Re: The Glen at Widefield Filing No. 9 Final Plat and CD's

Subject: Glen at Widefield No. 9 (SF18-5)- Review 1

GLEN AT WIDEFIELD FILING NO. 9
SPRING GLEN DRIVE (Sta. 43+00 to Sta. 45+89)
 PLAN AND PROFILE
 EL PASO COUNTY, COLORADO

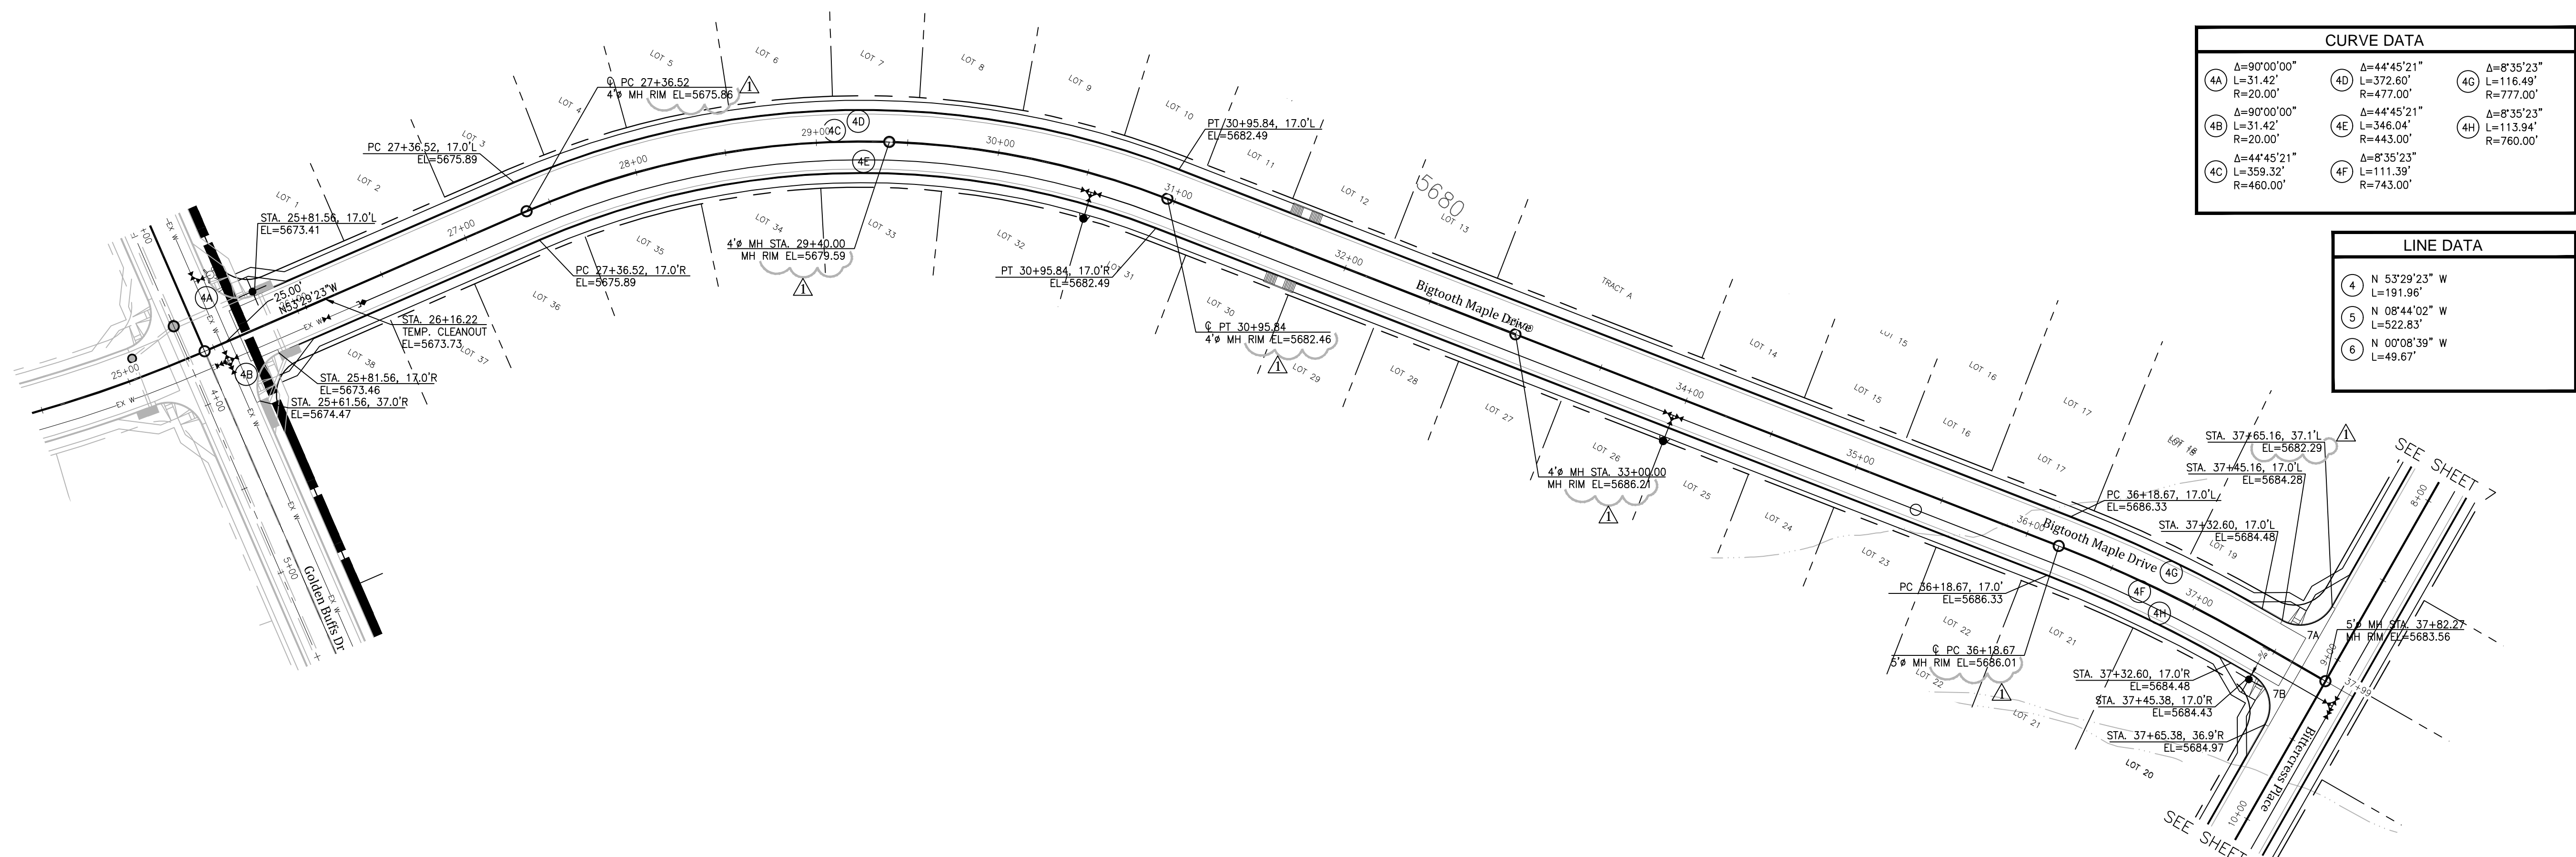
Review 1 comments to the developed condition drainage map is attached. ***Comments have been addressed per redlines.***
